To: The Examining Authority  
From: Stephen Fox, Interested Party (Ref: [REDACTED])  
Date: 27 December 2025  
Deadline 8 Submission  
Project Reference: EN010159 – One Earth Solar Farm

## Hydrological Audit

Subject: Cumulative Hydraulic Impact & Peak Flood Exacerbation

Outline Surface Water Drainage Strategy Plans

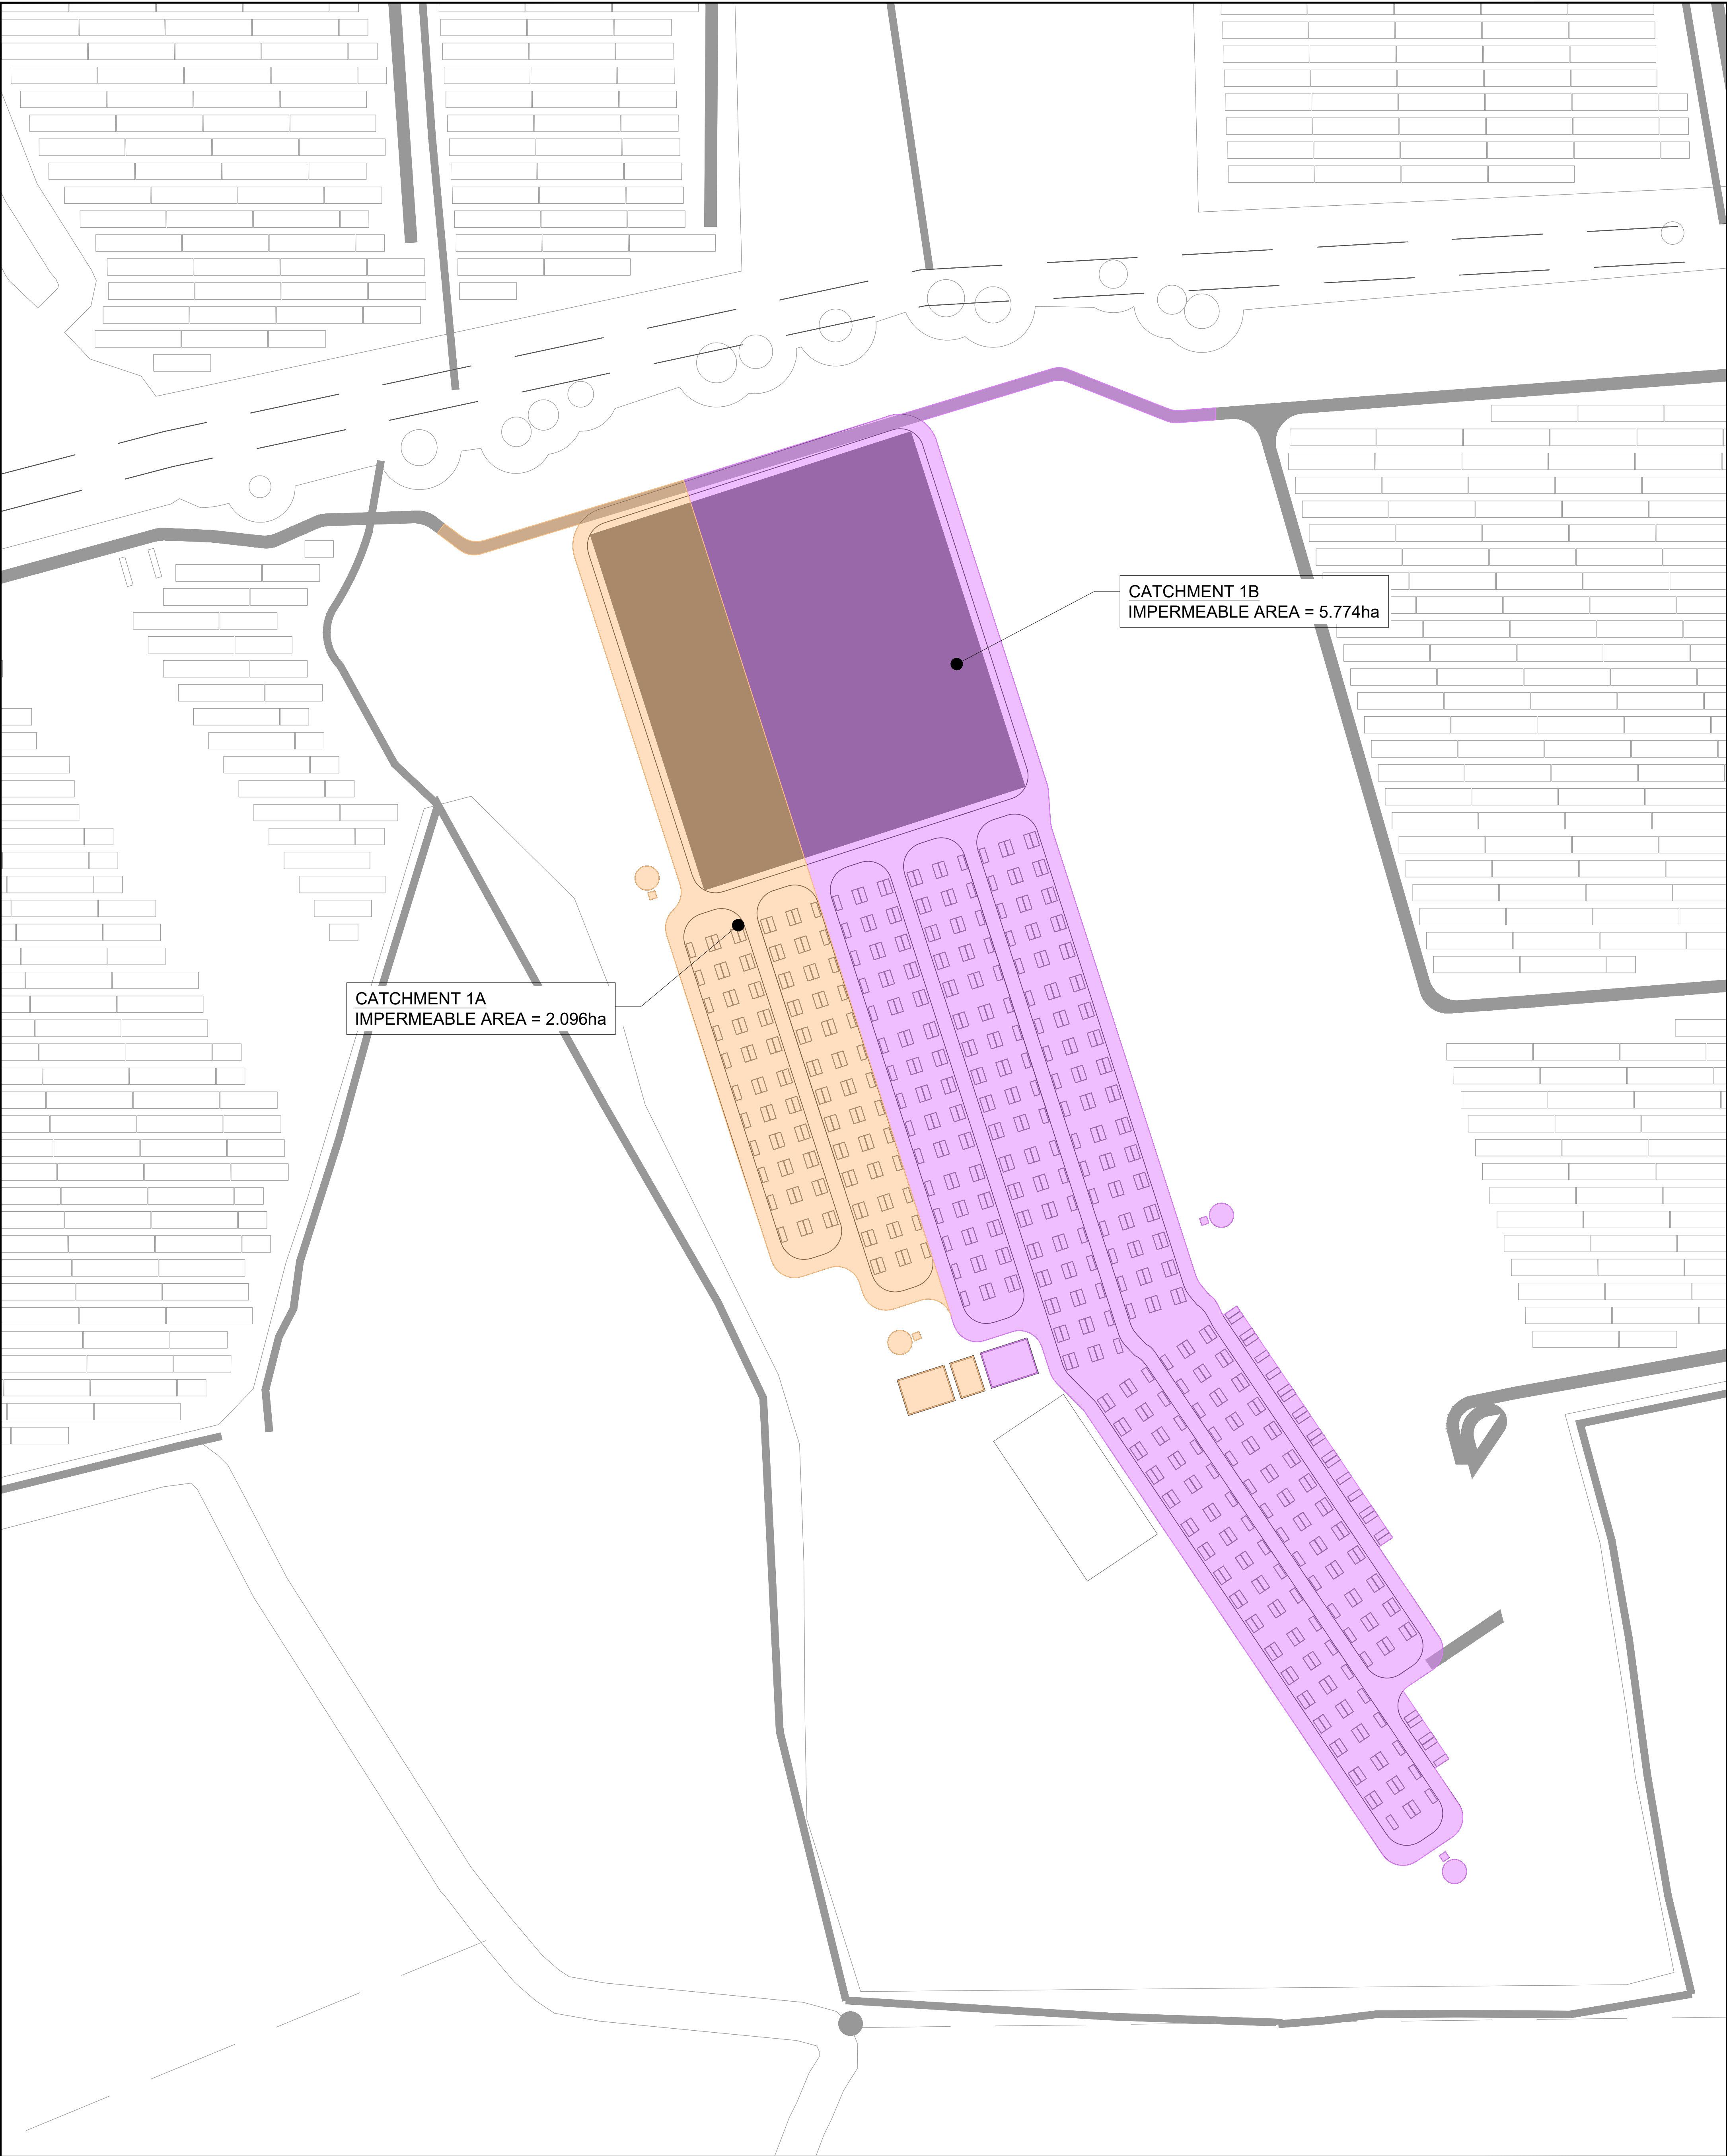
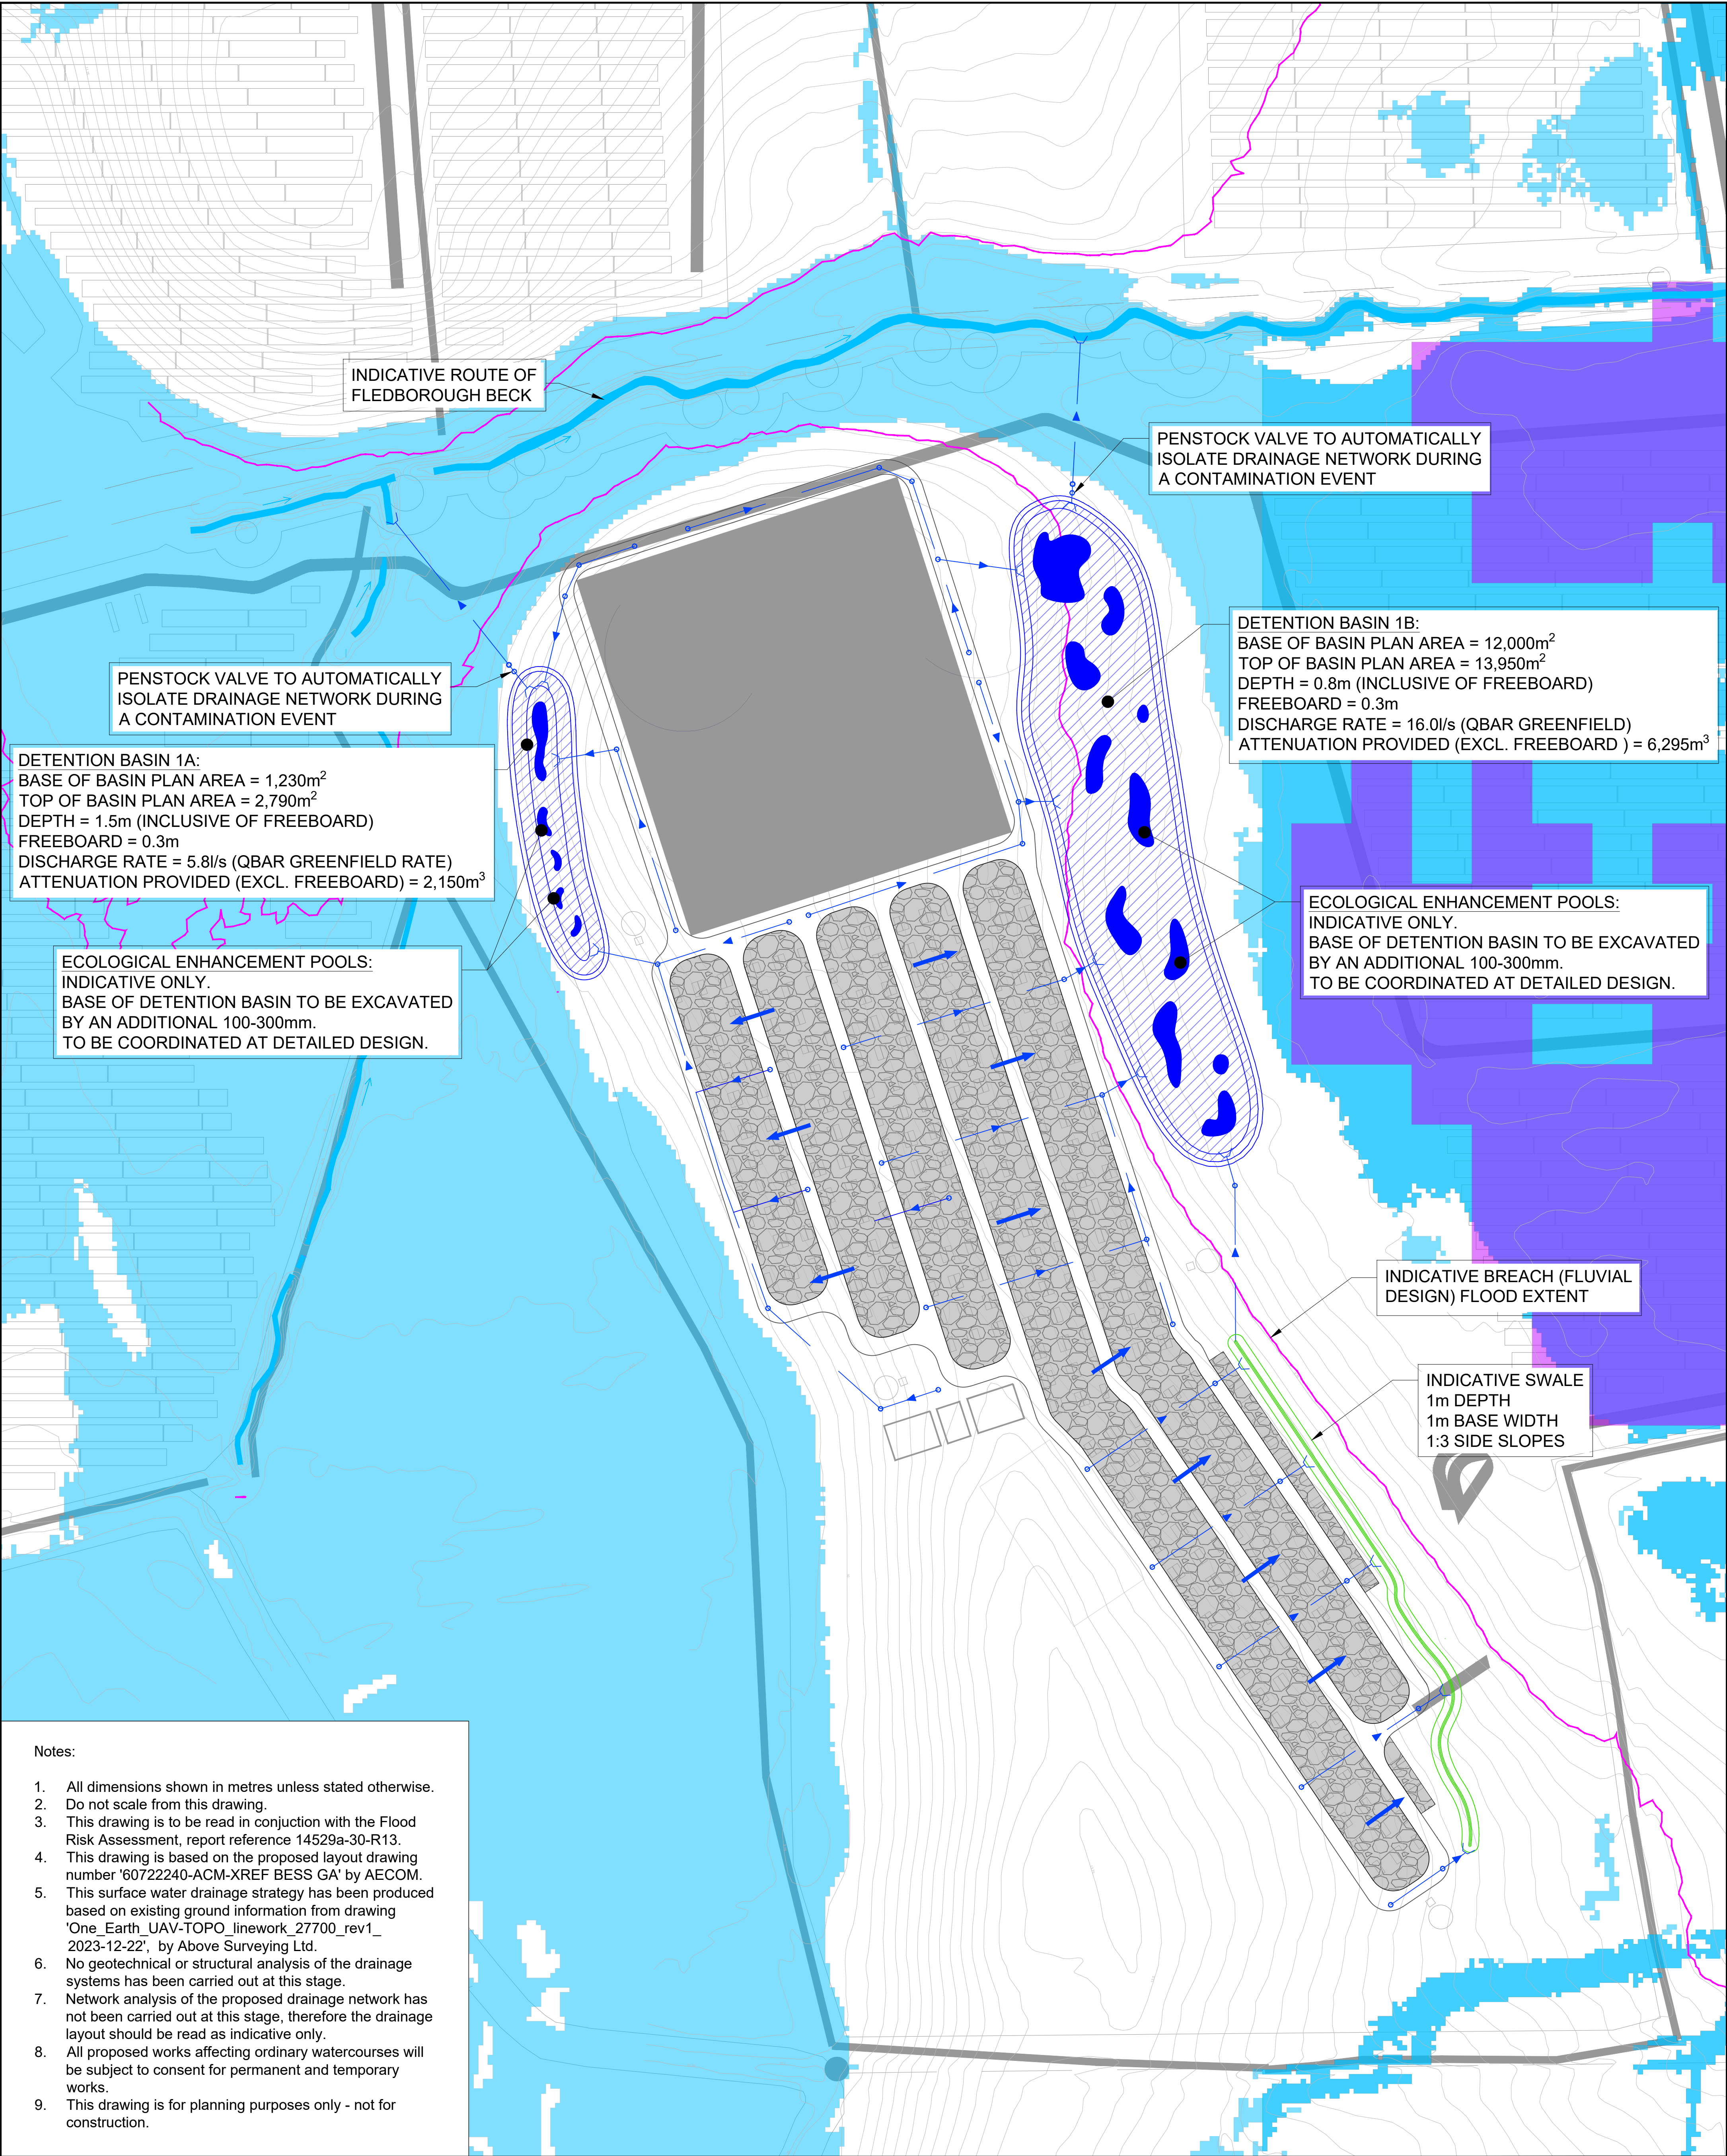
2.1.1. The Applicant's Drainage Strategy calculates runoff rates using standard "Greenfield" coefficients (ICP SuDS/FEH methods), treating the solar arrays effectively as permeable grass fields 5.

2.1.2. **Scientific Rebuttal:** This methodology ignores the physical reality of **Kinetic Energy Amplification**, as documented in *Baiamonte et al. (2023)* 4.

- **Concentration:** Solar panels are impermeable glass surfaces that intercept 100% of rainfall and channel it to the lower drip-line.
- **Amplification:** Water falling from the panel edge (height ~3m) strikes the ground with up to **11.7 times** the kinetic energy of natural rainfall 6.
- **Scour & Channelization:** On the site's **Foggathorpe 2** soils (slowly permeable, seasonally waterlogged clays) 7, this concentrated energy causes surface sealing and the formation of scour channels (rills).

2.3.2. **Conclusion:** If the "Glass Panel Effect" generates peak flows exceeding the "Greenfield" rates assumed in the model, the IDB ditches will be overwhelmed, leading to localized backing-up of floodwaters and increased risk to third-party assets in North and South Clifton.

1. **Model the "Glass Panel" Scenario:** Re-calculate runoff rates using a "contributing area factor" greater than 1.0 (to account for kinetic energy amplification) rather than standard grass coefficients.
2. **Run a Cumulative Joint Model:** Commission a single hydraulic model that includes the discharge from **all 5,953 hectares** of the Trent Solar Cluster to test for peak flow synchronization.
3. **Abandon the "5mm Loophole":** Acknowledge the physical volume of displaced water (39,900 m<sup>3</sup>) and provide Level-for-Level Floodplain Compensation for this volume.
4. **Secure TVIDB Consent:** Demonstrate technical approval from the Trent Valley Internal Drainage Board for the *actual* peak discharge rates, not just the theoretical greenfield rates.
